Applicant: Robert Nelson

Address: 38 Morse

CHECK-LIST AGAINST ZONING ORDINANCE

Proposed Use/Work - to Add 2 more units to an existing single family dwelling for a total of 3 res. d.u.

UNIT 1 FRONT ELEVATION UNIT 2

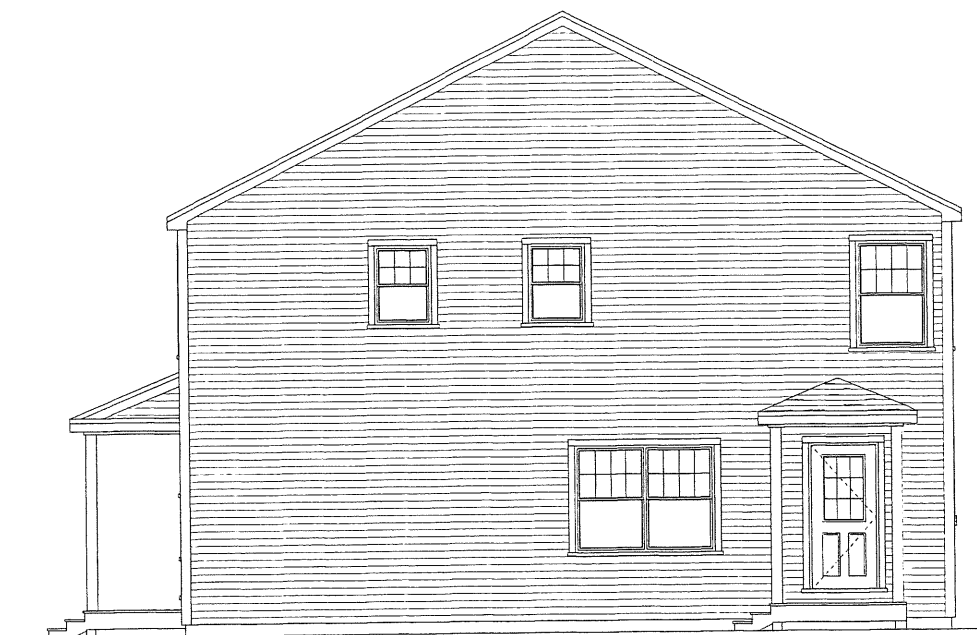
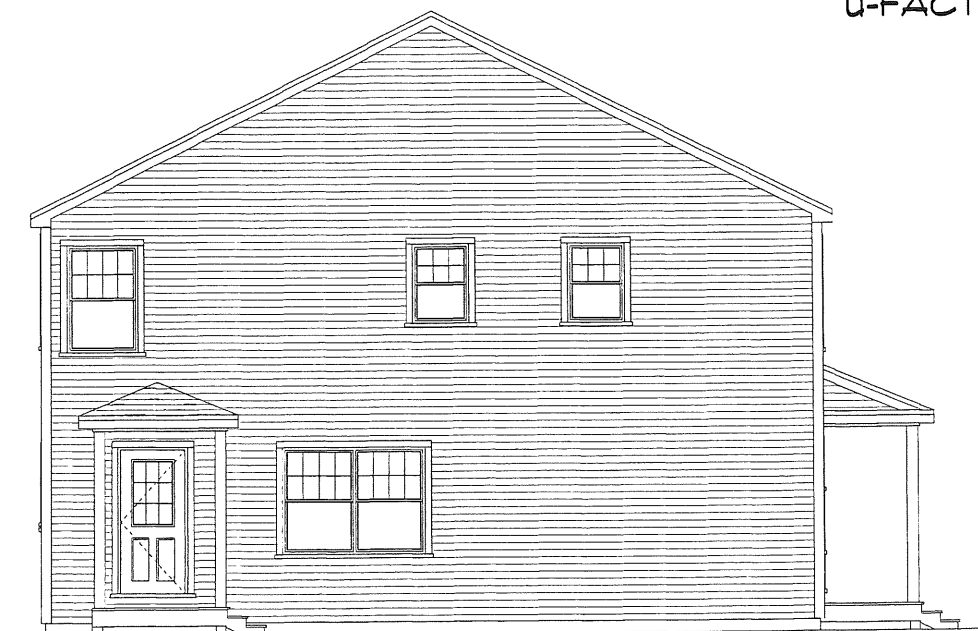
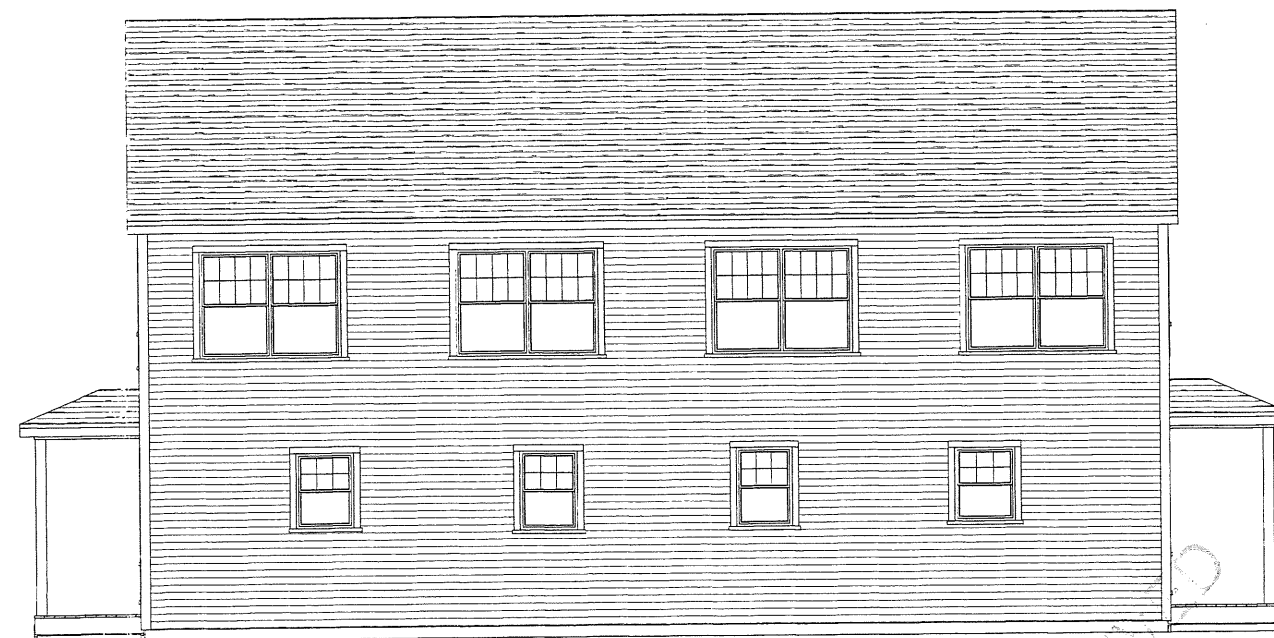
Height - 35' MAX allowed - 22.5' scaled

SITE PLAN
AT
38 MORSE STREET, PORTLAND, MAINE
MADE FOR
ROBERT C. NELSON
47 ALICE COURT, PORTLAND, MAINE

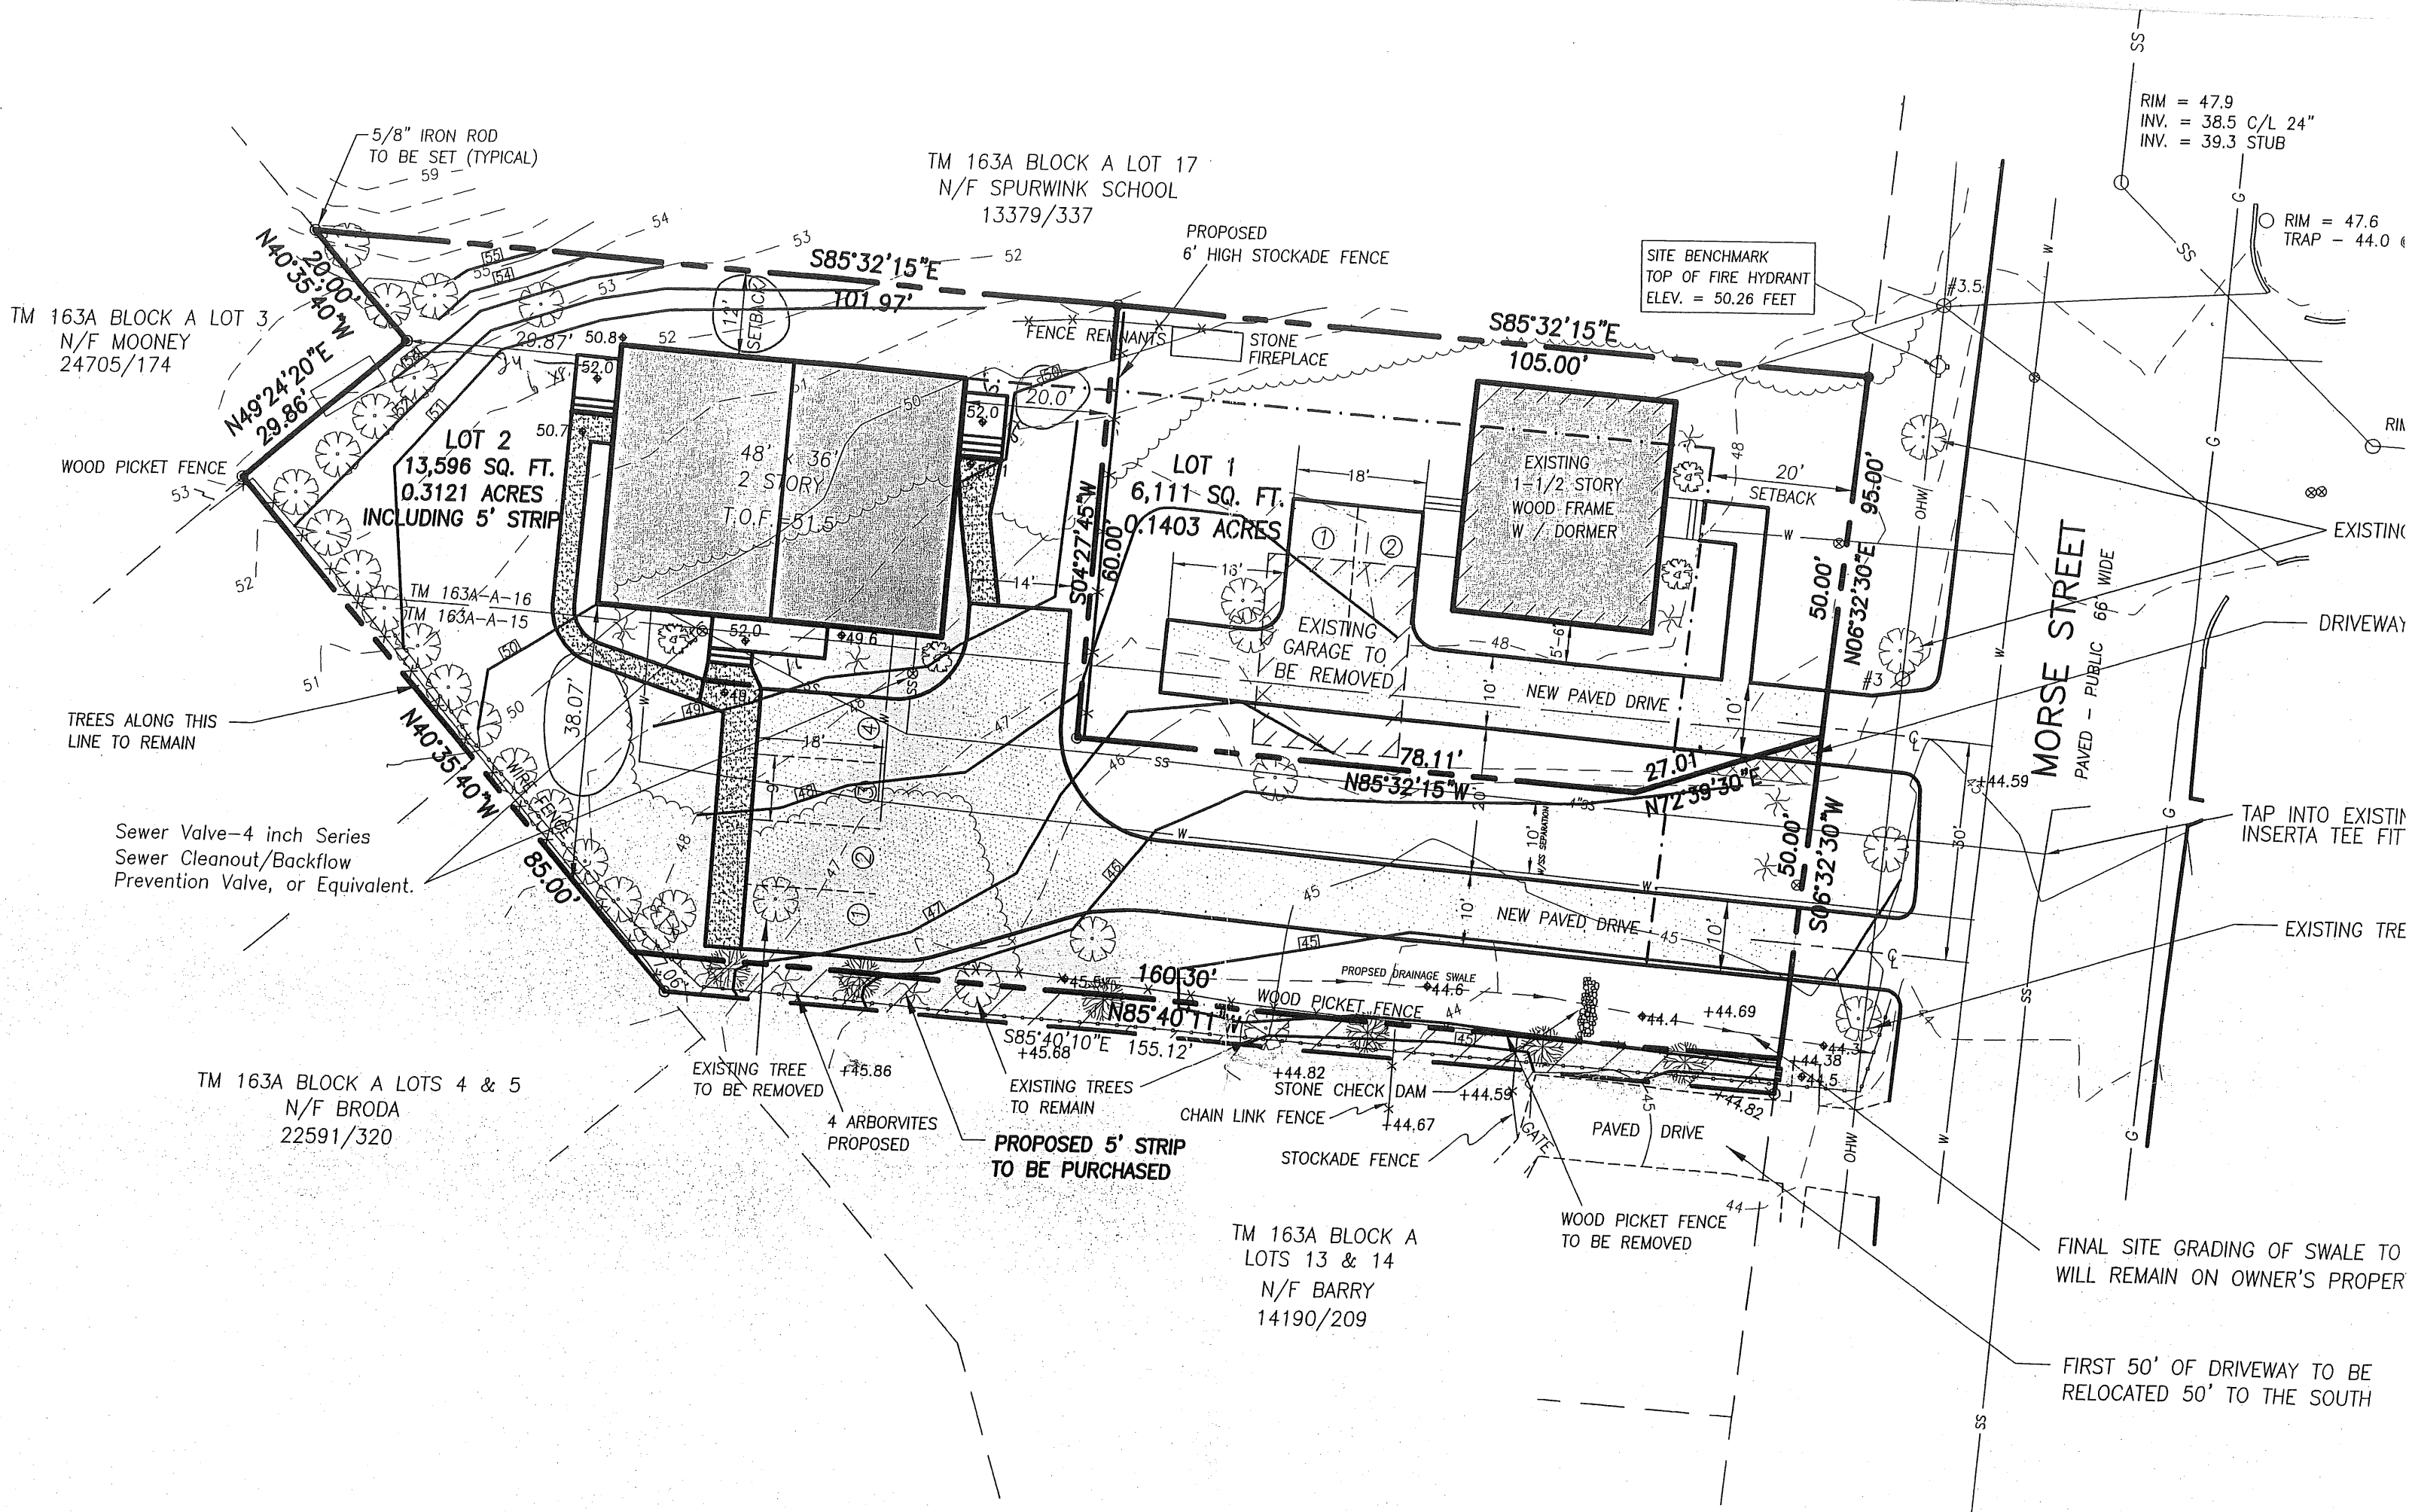
City 50' min - 95' shown

Front Yard - 20' req min - 68.75' scaled to closest new bldg

Rear Yard - 20' min req - 54' scaled to closest bldg

Side Yard - 12' for 2 stories - 12' & 12.5' shown & scaled

Width of Lot - 90' min - 95' shown

Lot Coverage/Impervious Surface - 40% MAX x 18,919 = 7567.6<sup>sq ft</sup> MAX COV. 18,919<sup>sq ft</sup> shown on Survey

Area per Family - 6,000<sup>sq ft</sup> per D.U. - a 18,000<sup>sq ft</sup> min - 18,919 given

Off-street Parking - 2 req per D.U. a 6 req - 6 shown
